DRB Application No.: 04DRB-00527-~~(P&E)~~^{SBP} Project # 1003370
 Project Name: ALAMEDA BUSINESS PARK
 Agent: Schlegel Lewis Architects Phone No.: 247-1529

**CITY OF ALBUQUERQUE
PLANNING DEPARTMENT
Development Review Board
April 14, 2004
Comments**

RE: Tract 28, Alameda Business Park/SPBP

V Site Plan

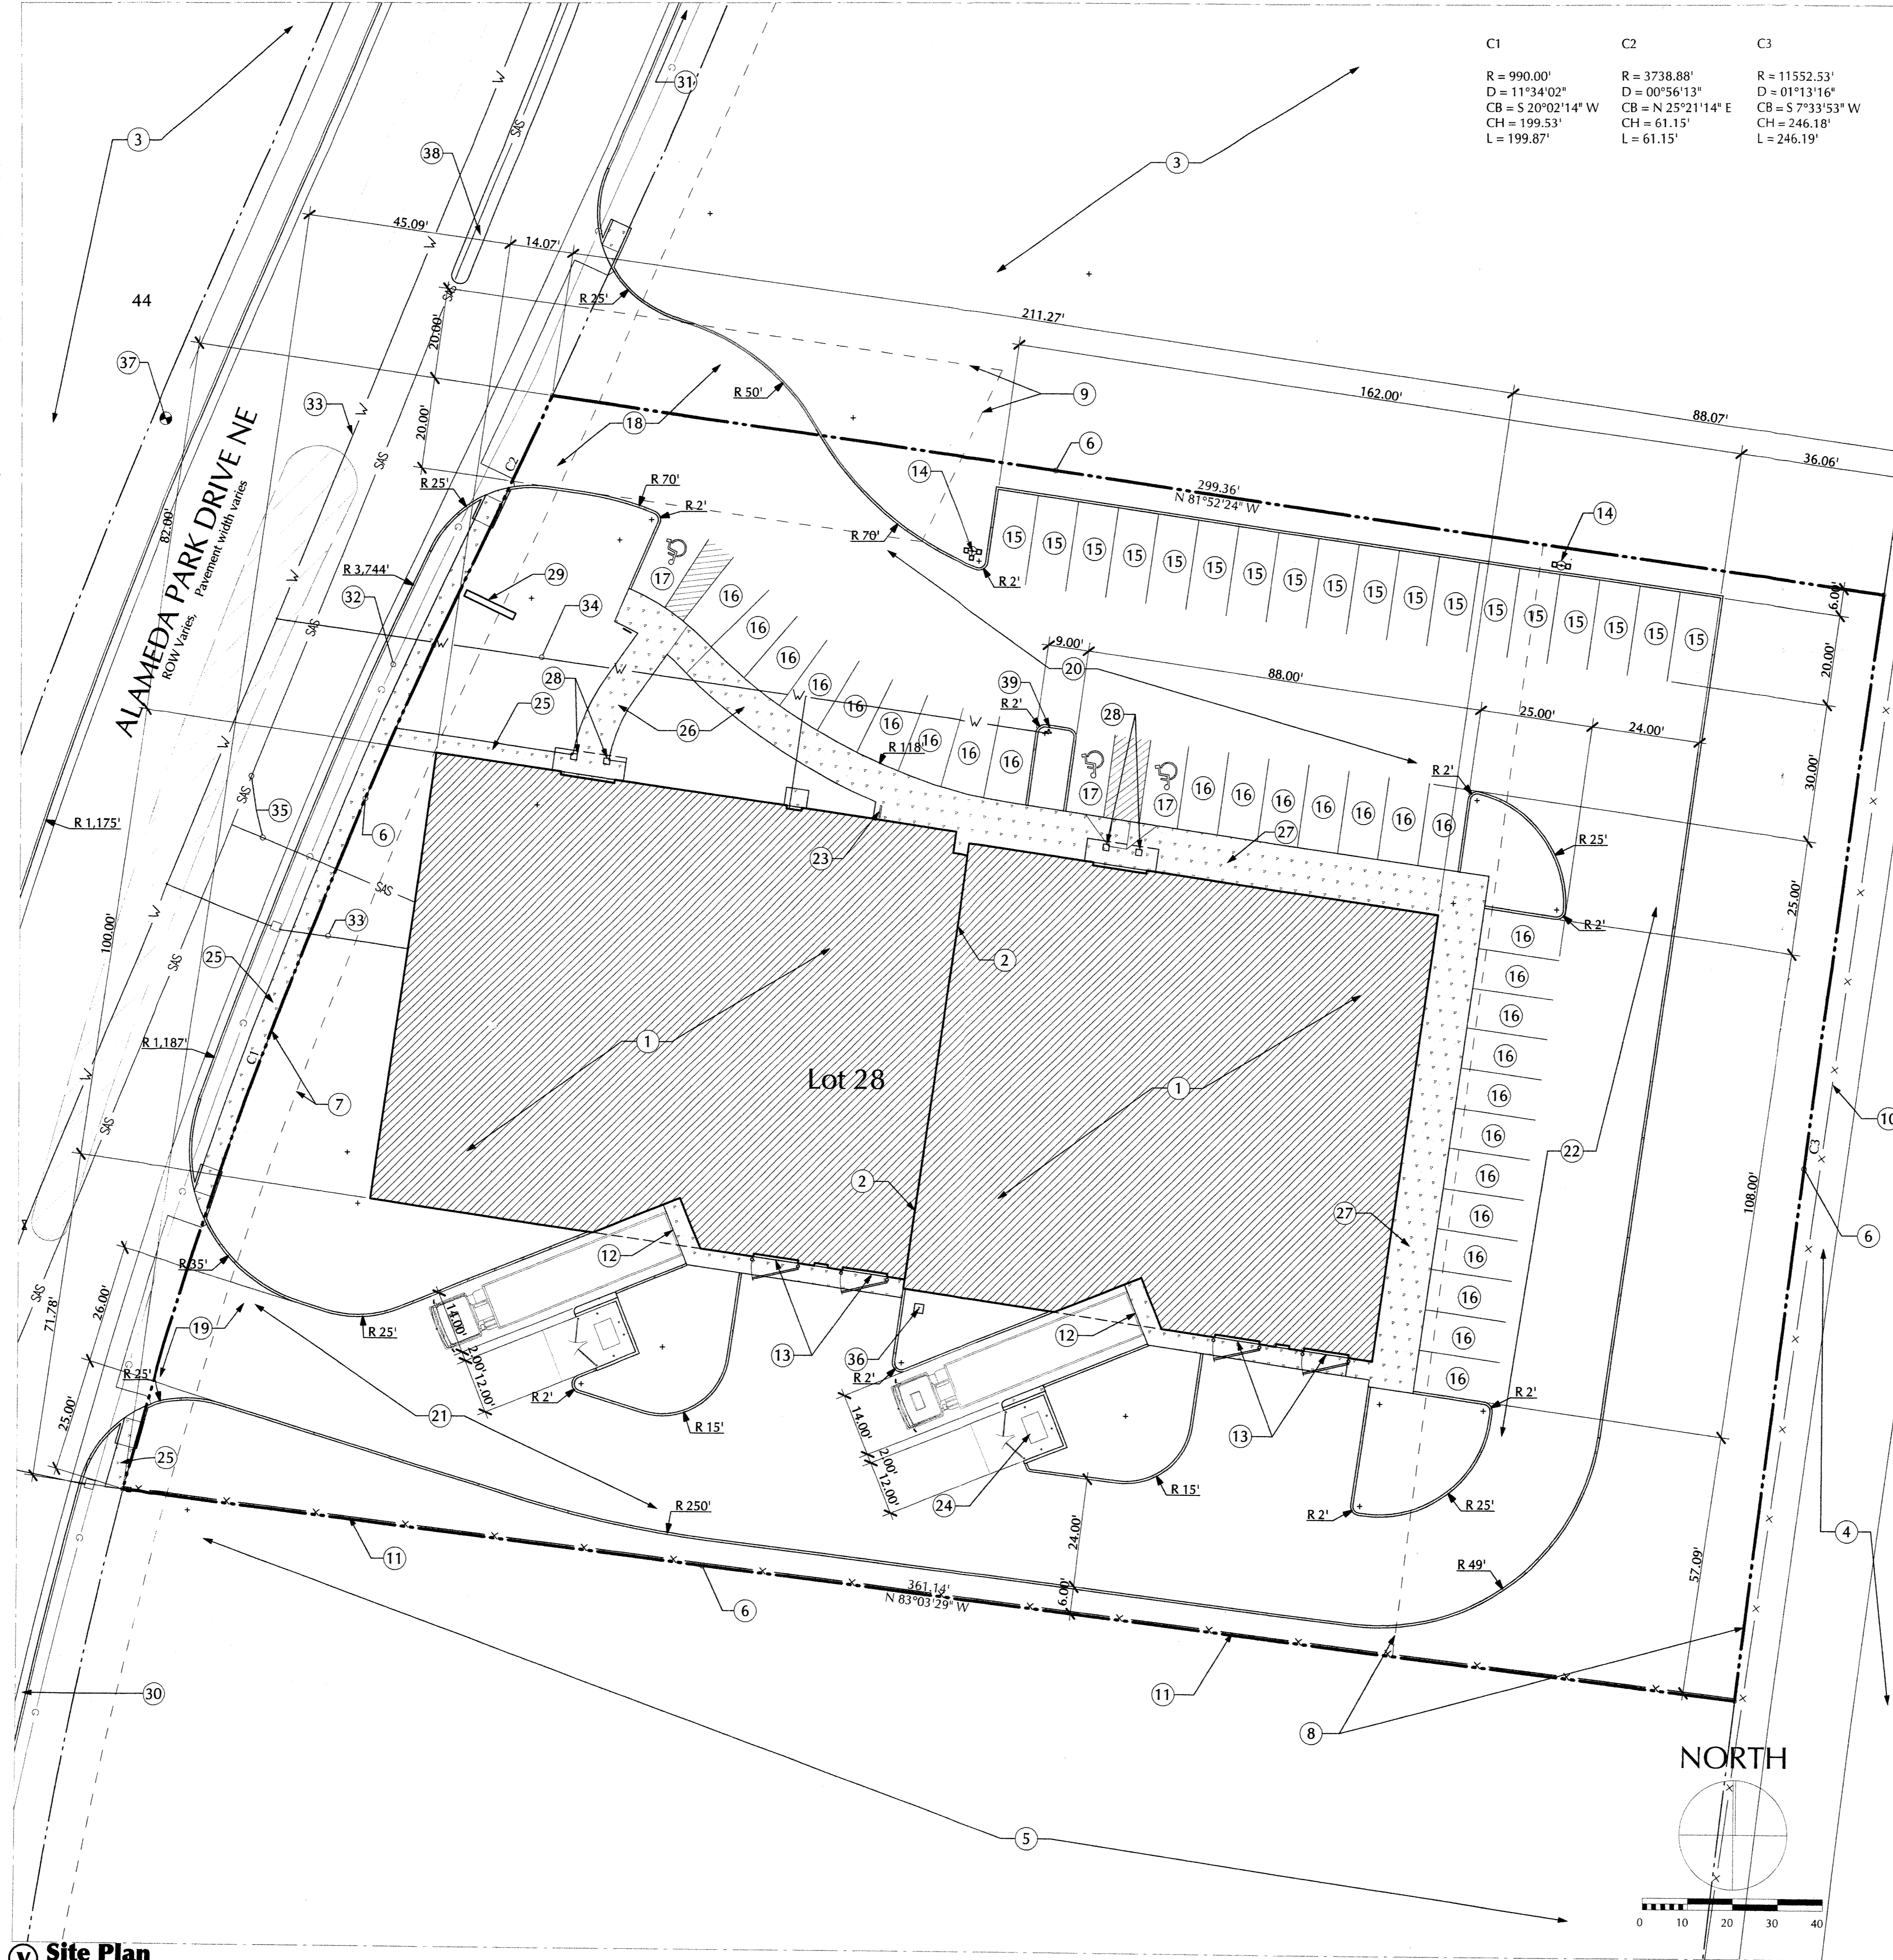
TRANSPORTATION: Need to expand X-access alignment on North Drive entrance to cover radius

- ✓ 1. The signature block should be on the site plan sheet rather than the cover sheet. Also, the signature block is not the one currently used. The Front Counter has the new one.
- ✓ 2. The property lines need to be more clearly defined on the landscape plan & site plan sheets. Bolder lines should suffice.
- ✓ 3. Because the rear of the lot backs up against a City park, the fence running across the back falls within the 30 day moratorium on walls & fences which abut a public park. If you submit a design for the fence which meets the proposed zone code amendments on perimeter walls and follow the submittal requirements in terms of number of copies, size of submittal, etc, and this design is approved by myself & Juanita Vigil, a staff planner, your site plan can proceed.

- ✓ 4. The parking space calculations, what's required and what's provided, are required on the site plan sheet.
- ✓ 5. Landscape Plan. Please remove all junipers as they are a high allergen plant. There are several misspelled words on this sheet. The Alameda Business Park Master Plan requires a 10' landscape buffer as a front yard setback. This is lacking.
- ✓ 6. Roof Mounted Equipment. The Alameda Business Park Master Plan states: "Roof equipment screens are to be at least as high as the equipment." The current elevations sheet detail does not conform to that requirement.

ok 6/10/04
